2024/1065

Address: 103 Furlong Road, Bolton Upon Dearne, Rotherham, S63 8HB

Description: Erection of single storey rear extension (rendered in white) on a 2 storey terraced dwelling.

SHEET
Proposed Plans & Elevations

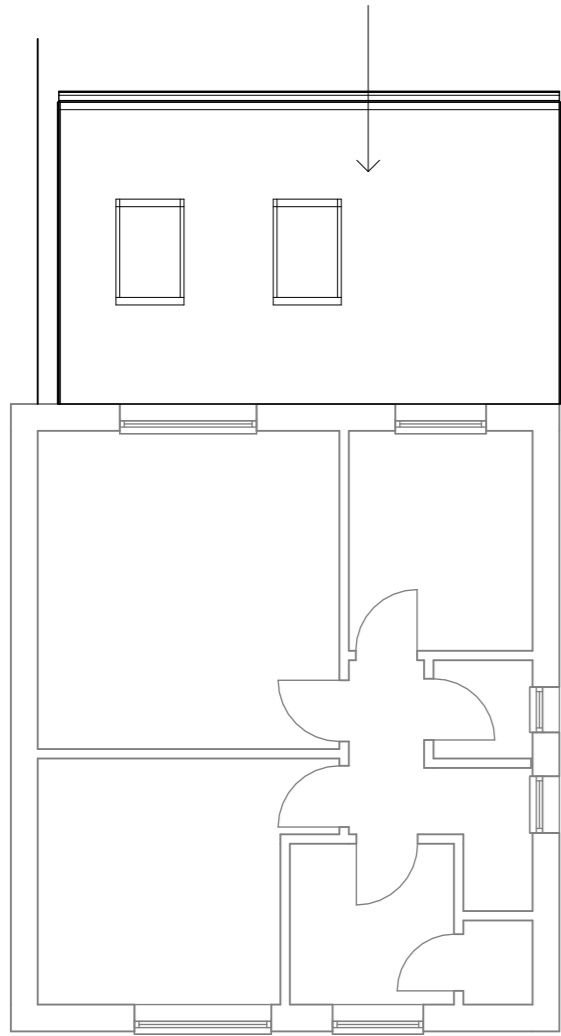
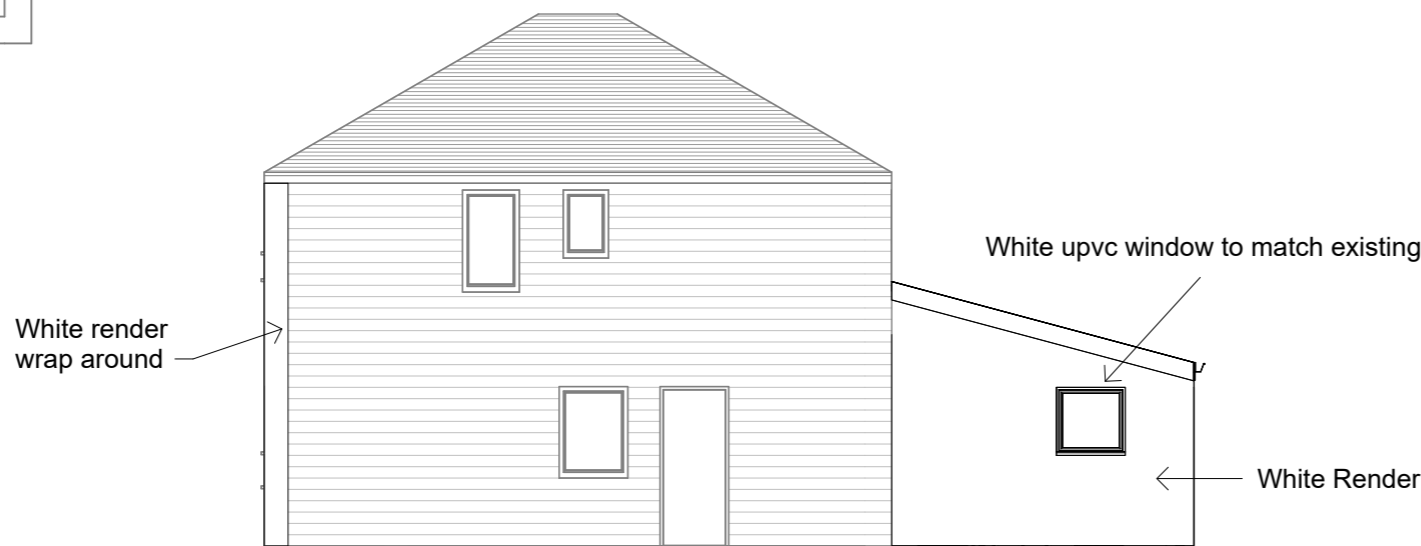
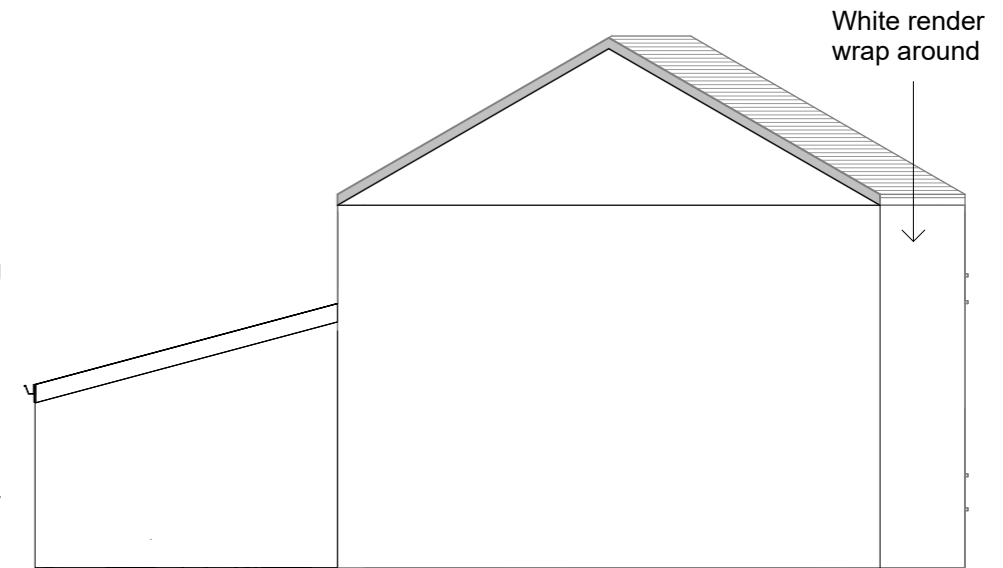
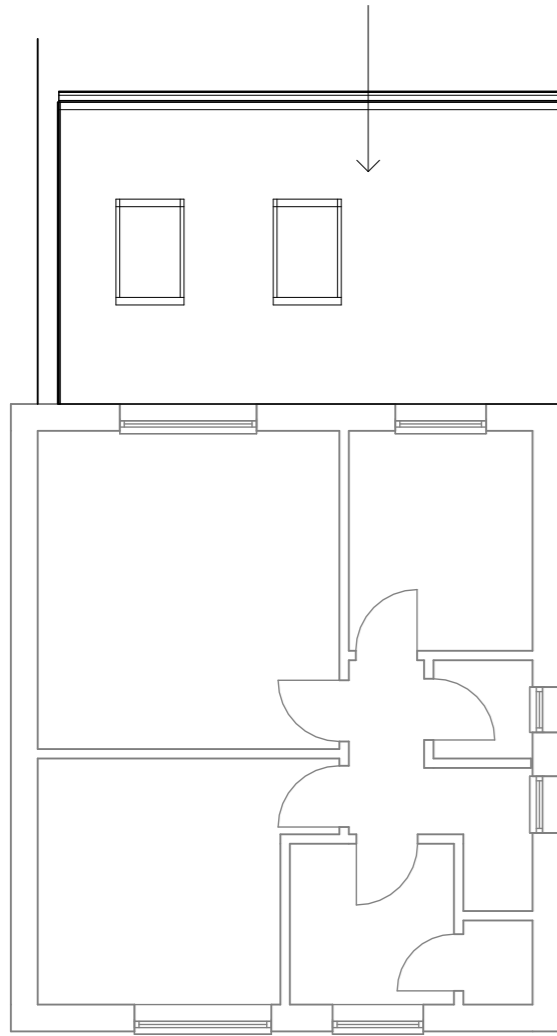
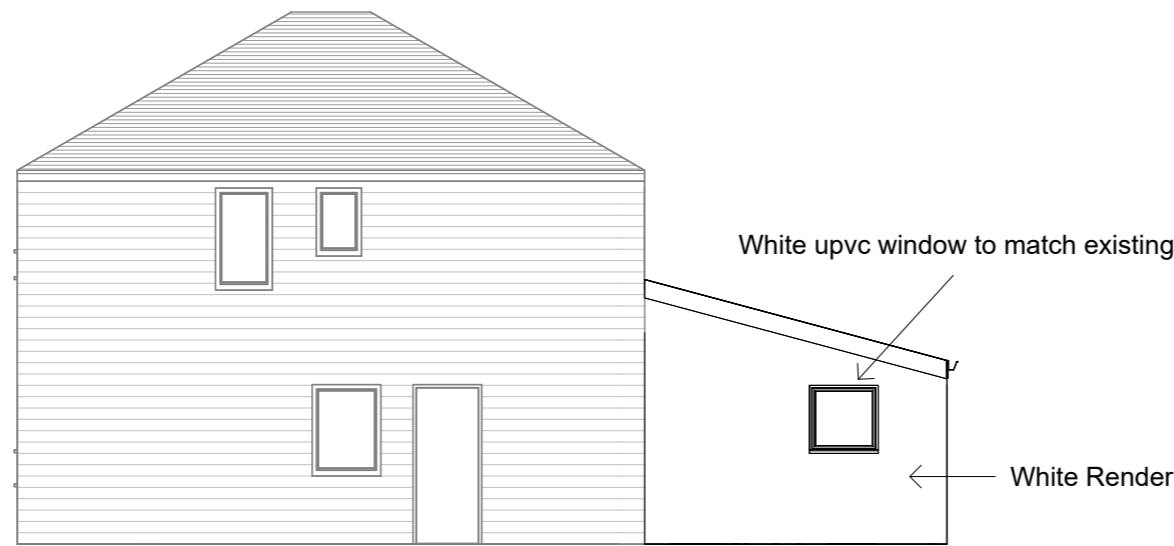
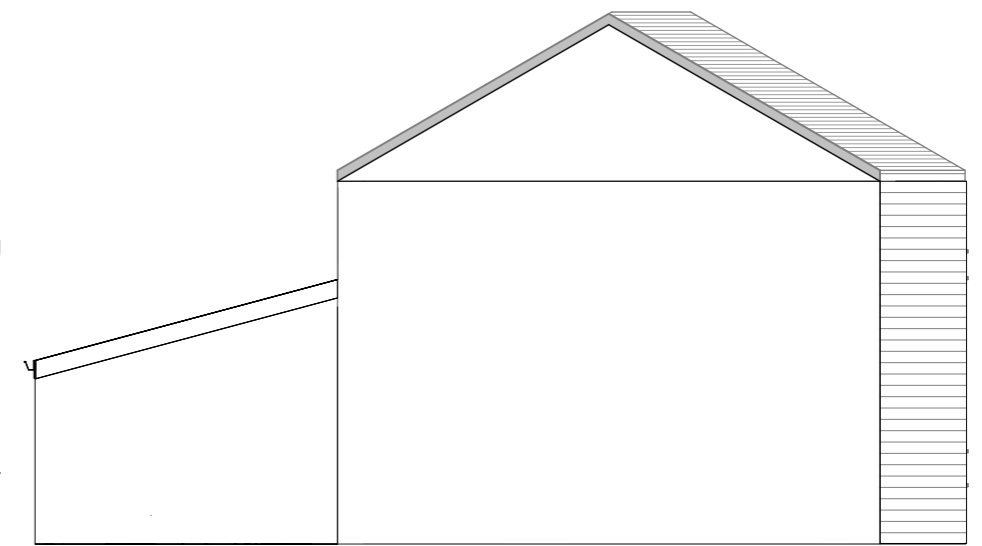
The original proposal included plans to render the whole dwelling in white render, to accompany the proposed single-storey rear extension. Following a request, amended plans have removed the render from the original dwelling, resulting in a revised proposal of a rear ground floor extension, with a sloped roof. The extension but not the house would be rendered in white, and would feature a sloped roof design with matching grey tiles.

The current ground floor extension has never been considered significantly detrimental to the character of the dwelling nor to the visual amenity of the area, especially in consideration of the adjacent Tesco store and the extension's position on the rear elevation. In contrast, the proposal for the whole house to be rendered in white would have had a significant negative effect on the character of the dwelling, the quartet block of dwellings it resides within, and potentially the broader street scene of the three terrace blocks. Whilst much of the street scene is varied, the three blocks of terraces remain and would ideally continue to remain unaltered to retain this section of the street's original character.

Following the amendments to the proposal to remove the render from the original dwelling, the extension would maintain visual amenity given its modest size and non-prominent location. As such, the proposal would meet the requirements of policy D1 and the SPD.
